From: tomeodell@gmail.com
To: [Deb Estrada](#)
Subject: Leyland Cypress
Date: Wednesday, January 24, 2024 11:25:15 AM

SHEET NAME:  
**TR-01**

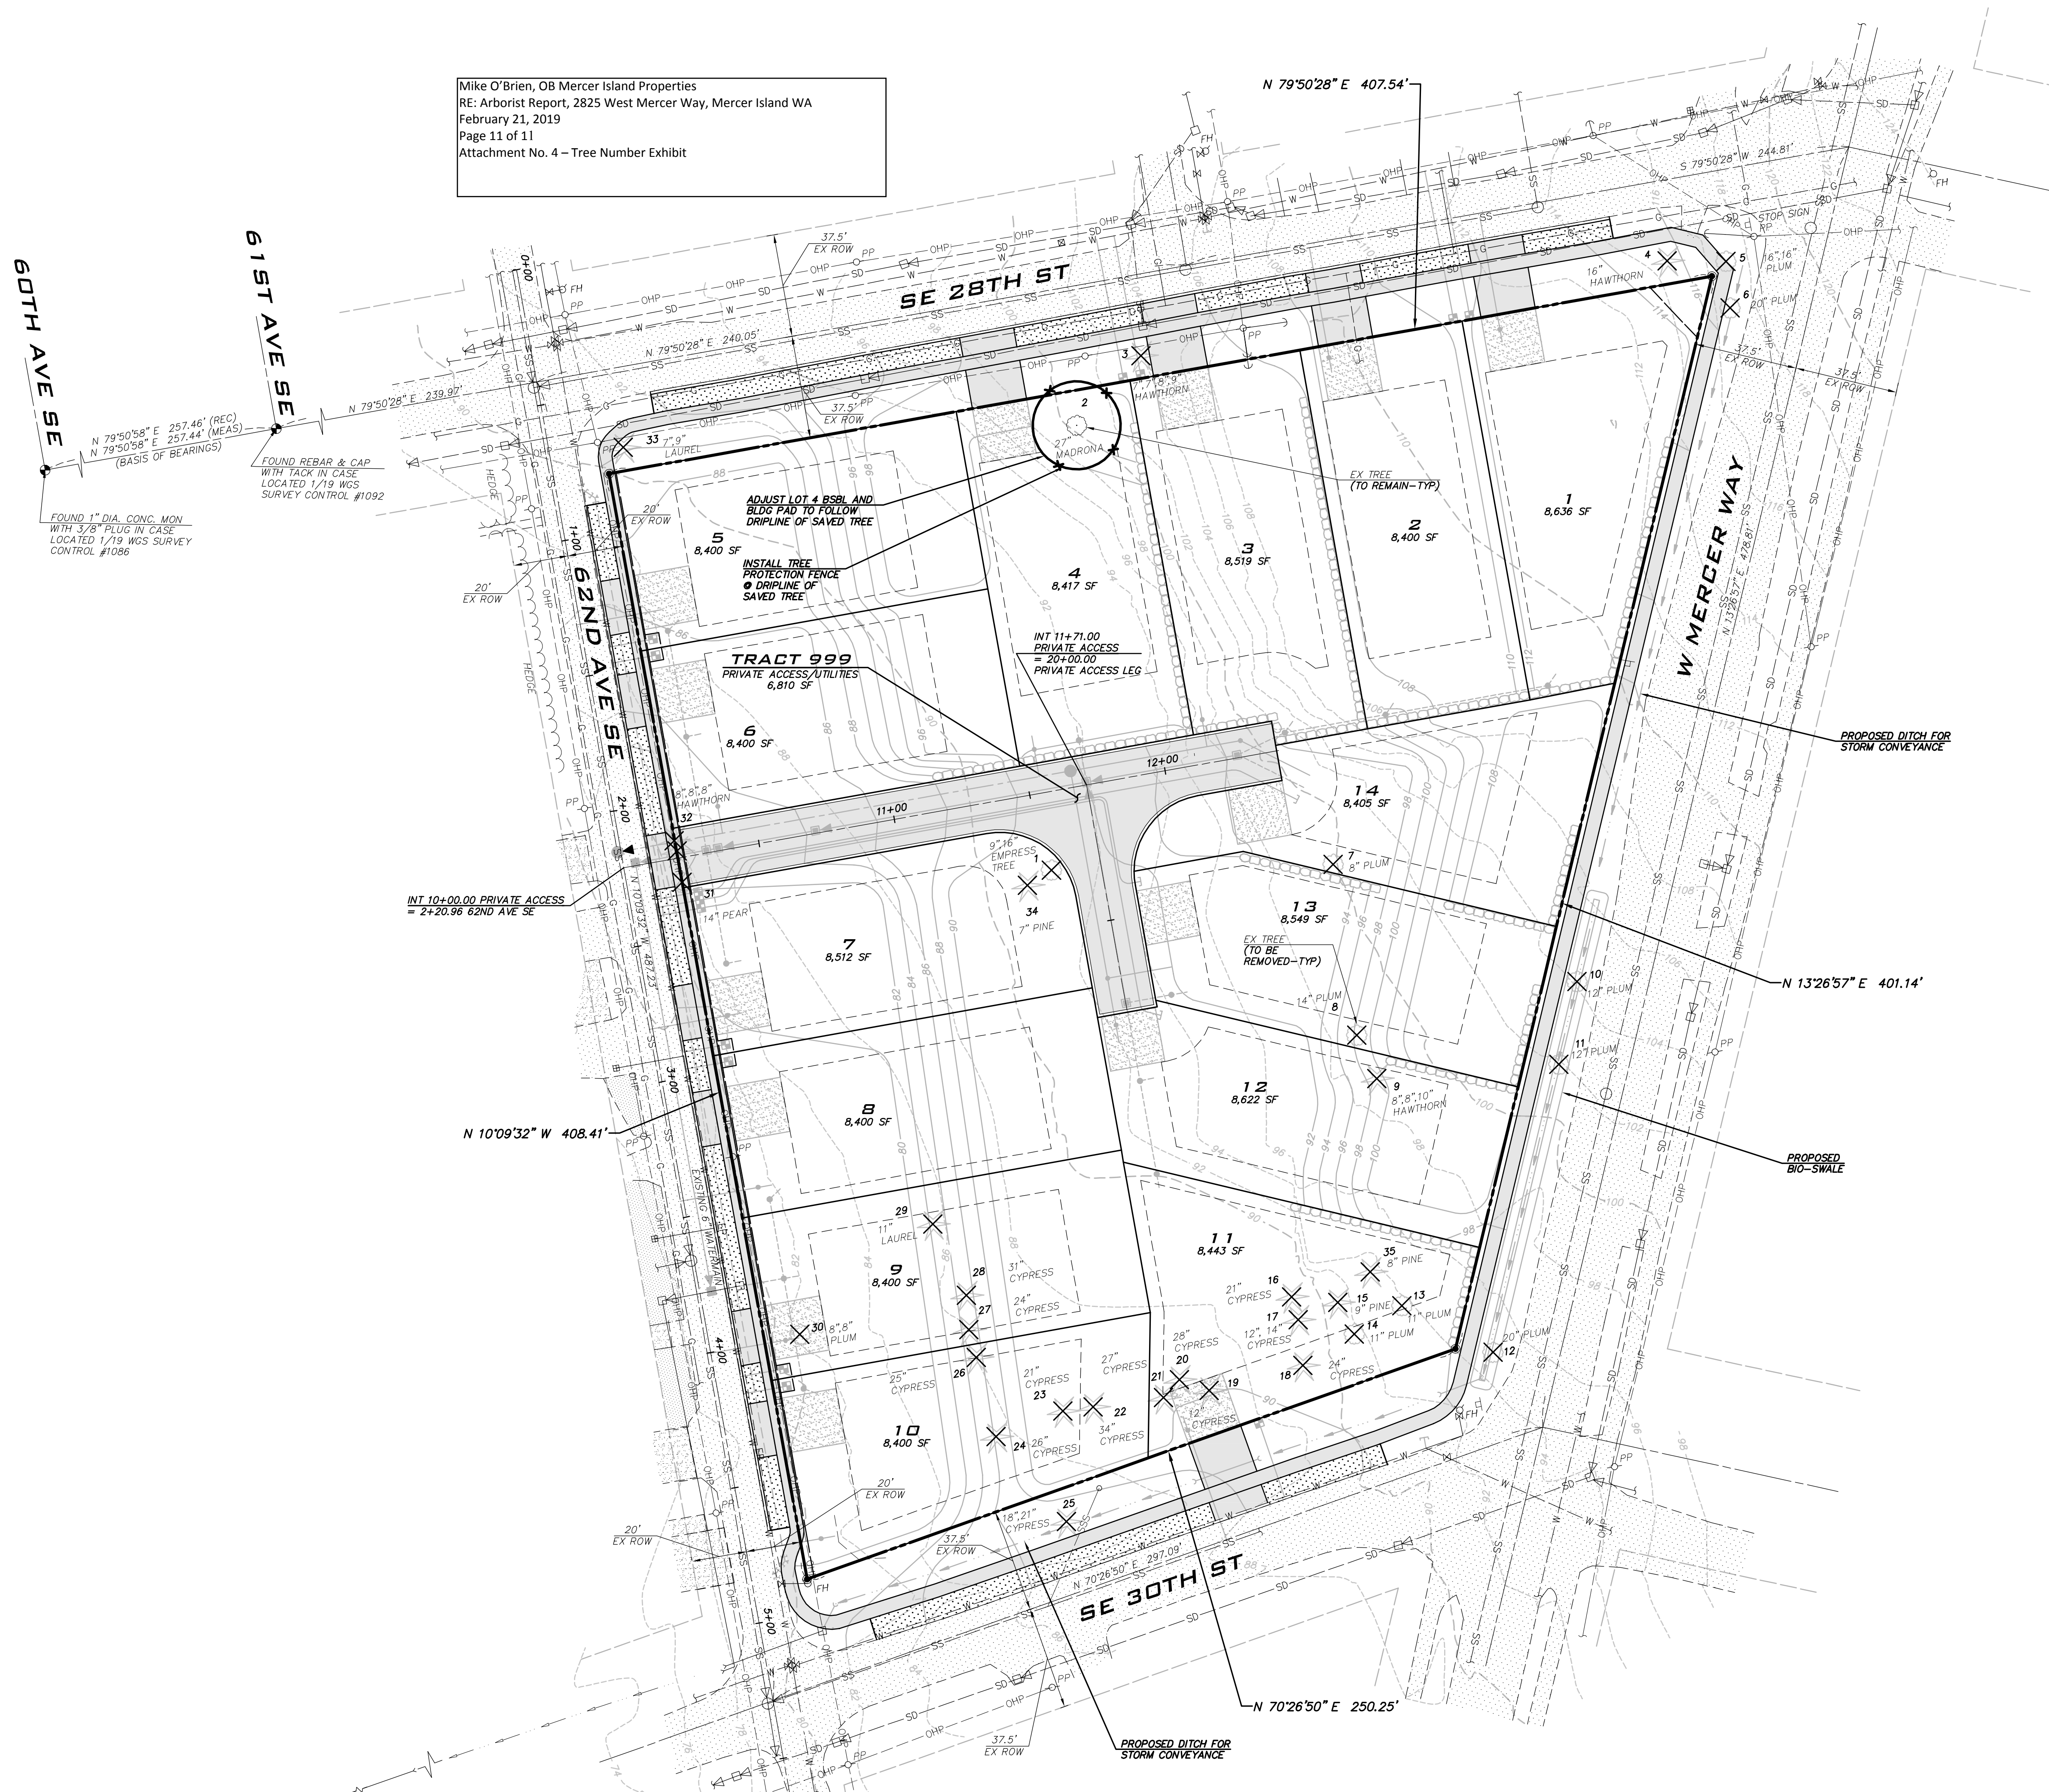
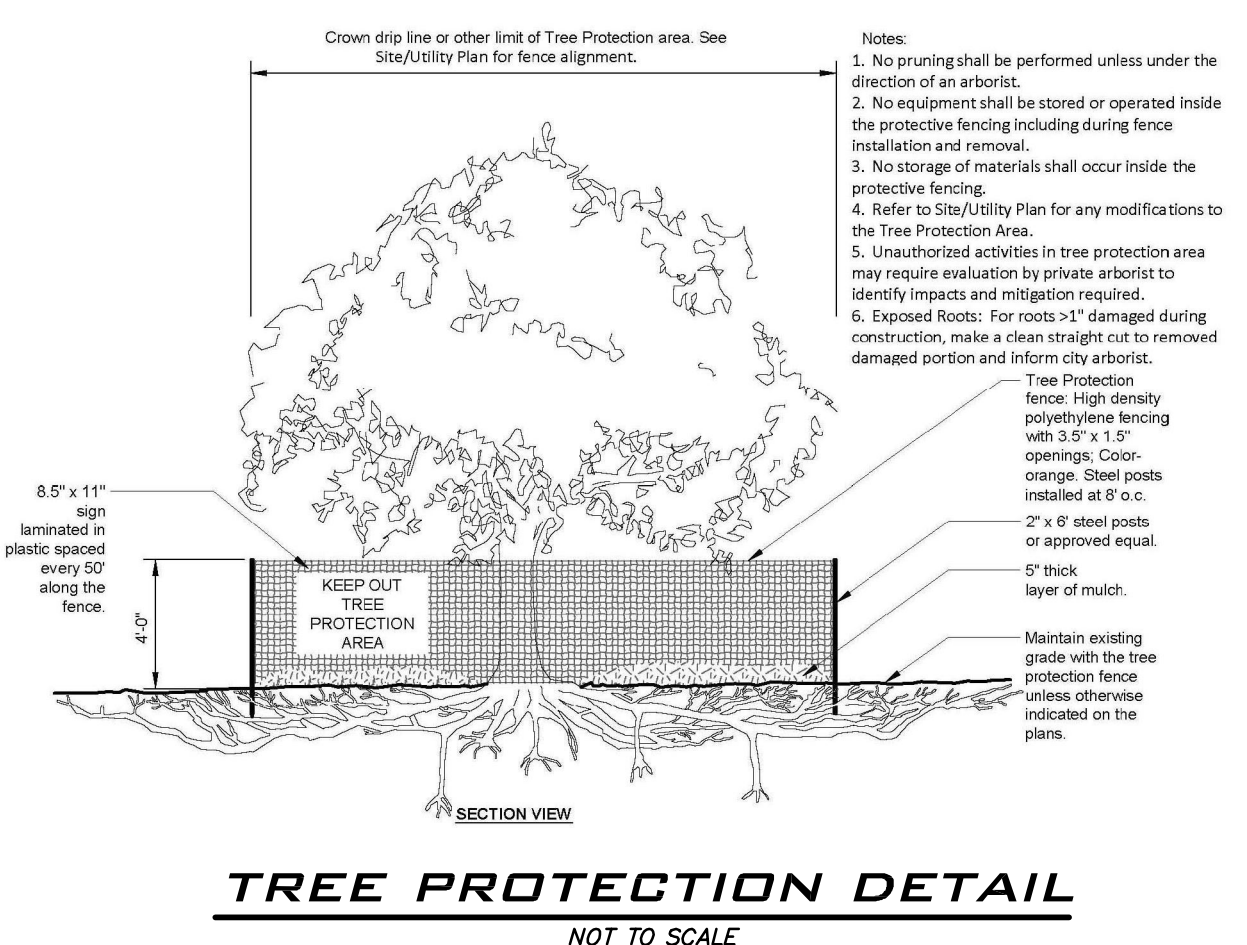
The trees that the arborist is referring to are not Leyland Cypress Trees. They're Austrian Pine trees. They are substantially different from a Leyland Cypress.
